Your ref: 3/2018/0956 and 0958

Date: 5<sup>th</sup> November 2018

**Planning Applications 3/2018/0956 and 0958: Application and Listed Building Application for retention of unauthorised alterations at first floor to create five guest bedrooms. Three Millstones Inn, Waddington Road, West Bradford BB7 4SX**

FIRST FLOOR PLANS

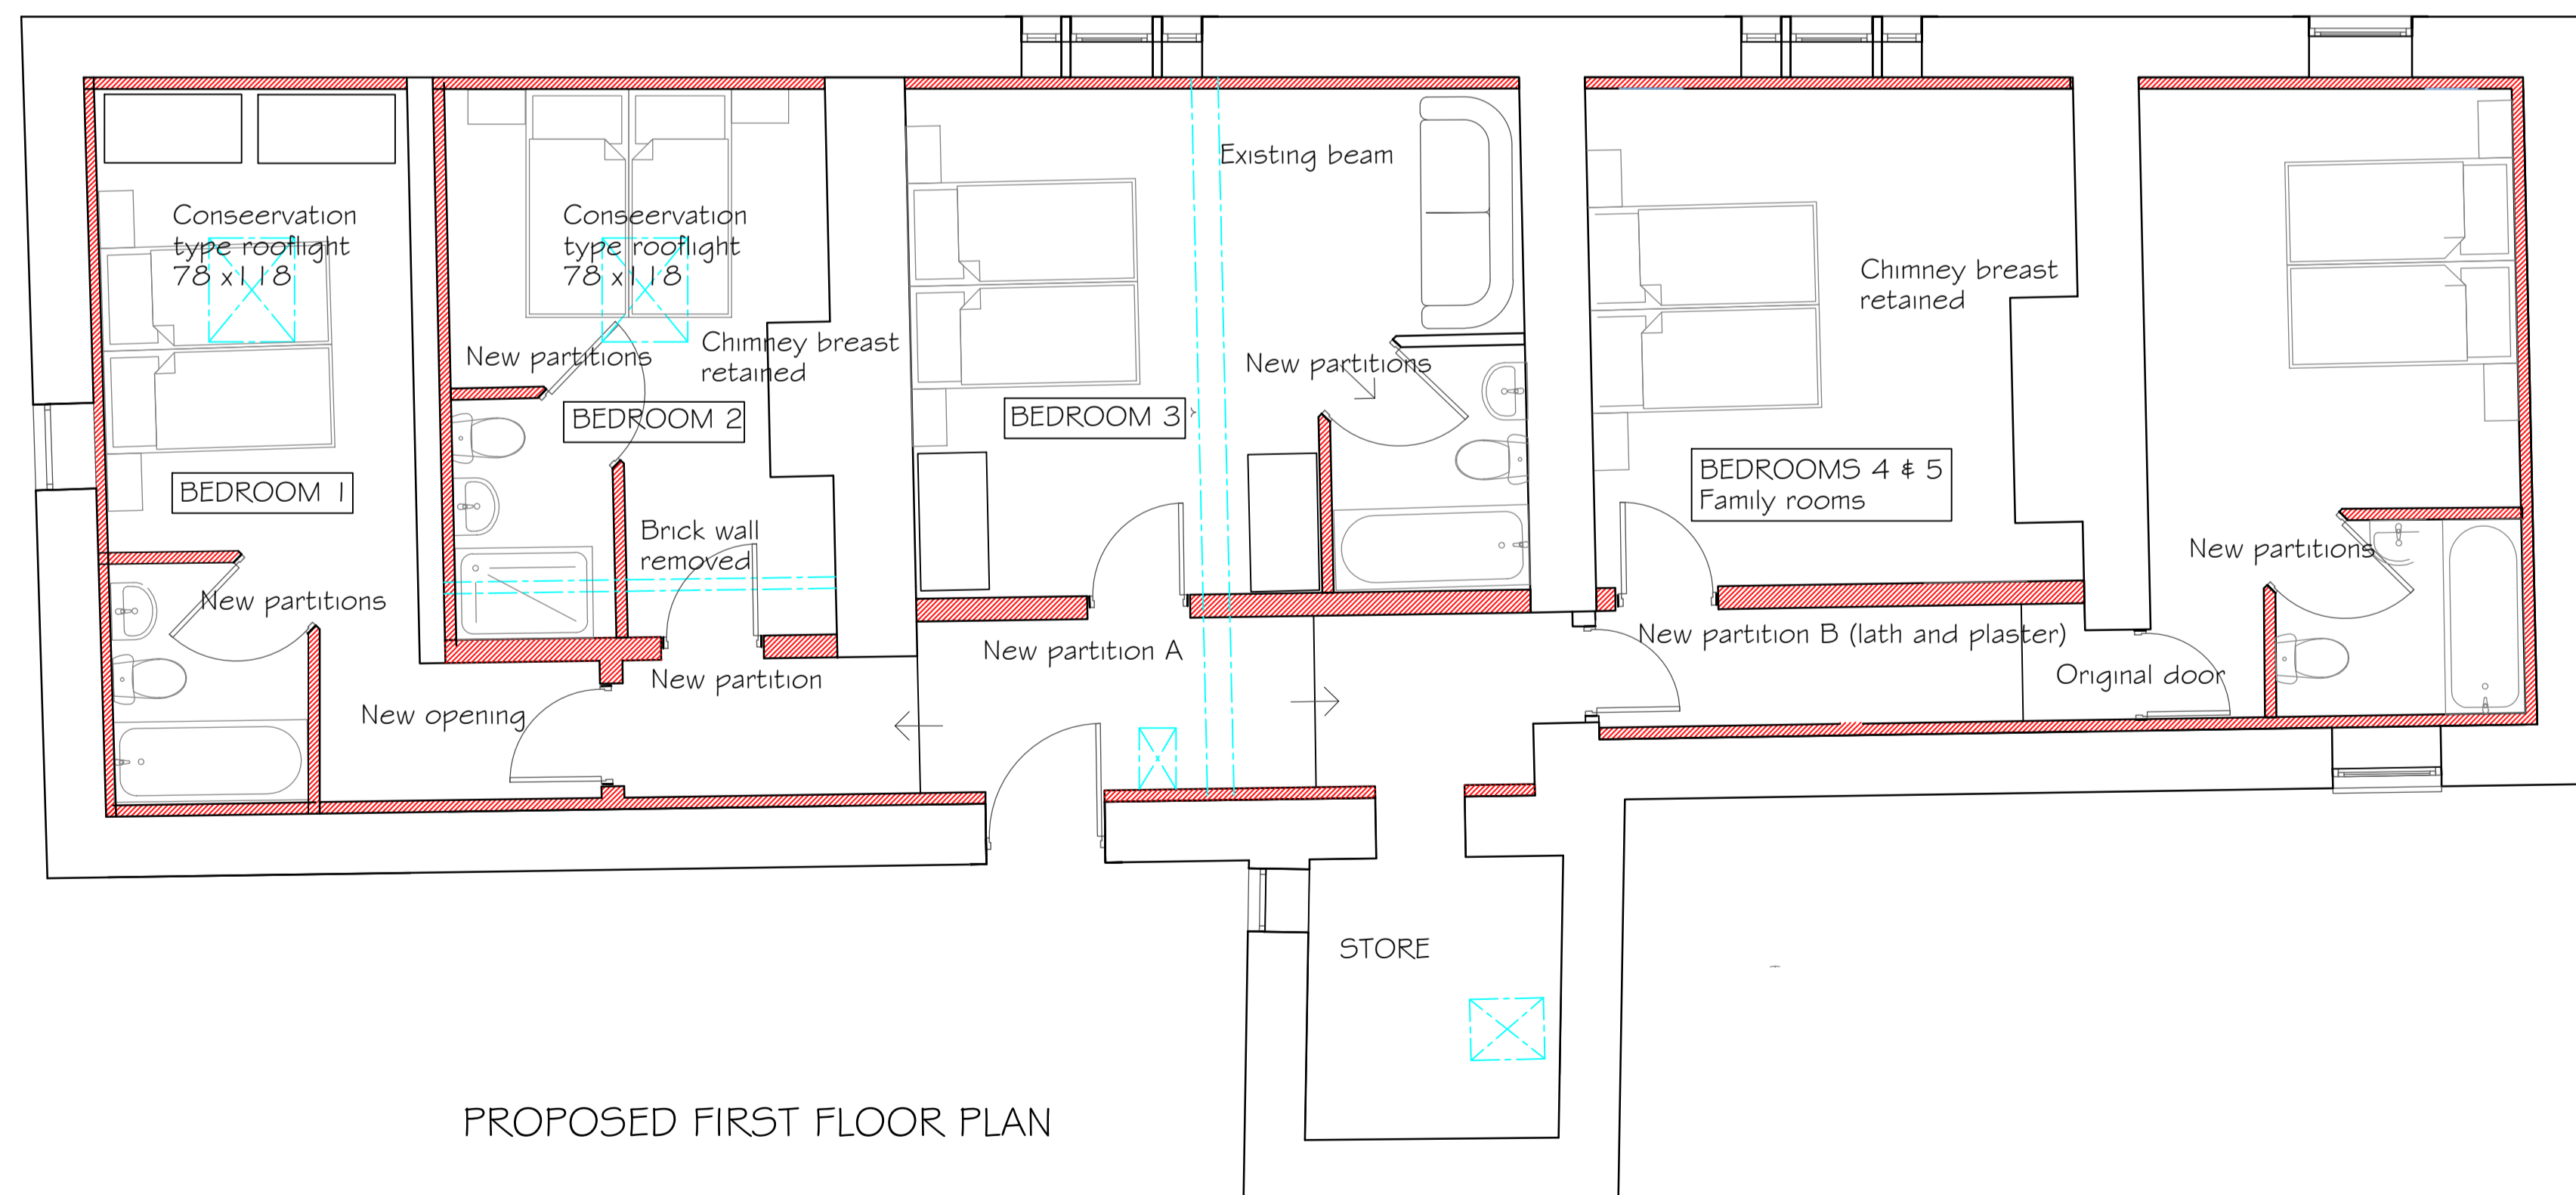
Thank you for our consultation on the above applications. They are accompanied by a Heritage Statement (HS) by Ian Rowan, dated May 2018. Whilst we would agree with the statement there that it would be better for these rooms to be refurbished and contribute to the financial security of the business, the assessment is brief and it would have been useful if rather more detail had been provided either there or in other application documentation. For instance it is unclear how the upper floor is currently accessed and where any historic stair would have been (if different), and thus what effect the proposed changes would have on the historic plan form and circulation pattern. Images are provided of the lath and plaster work and of the brick and plaster work, both of which would appear to be later alterations, but other elements impacted or mentioned in the description (e.g. older doors, room at eastern end, fireplace at western end) are not illustrated. There is no information provided on the roof structure and how the new or altered roof-lights for bedrooms 1 and 2 will impact it (the passageway and store roof-lights do not seem to be changing). There is also no information on the new service runs that will be required for the new en-suite provision, and if that will impact the historic fabric.

We would recommend that further detail on the proposals is submitted, which allows a full picture of the impact of the proposed changes to be assessed. If these prove to be acceptable, we are likely to recommend that any works are preceded by a more detailed photographic record of the building, to the standards set out by Historic England in "Understanding Historic Buildings" (2016). Such work can be required by a planning condition. The following wording is suggested:
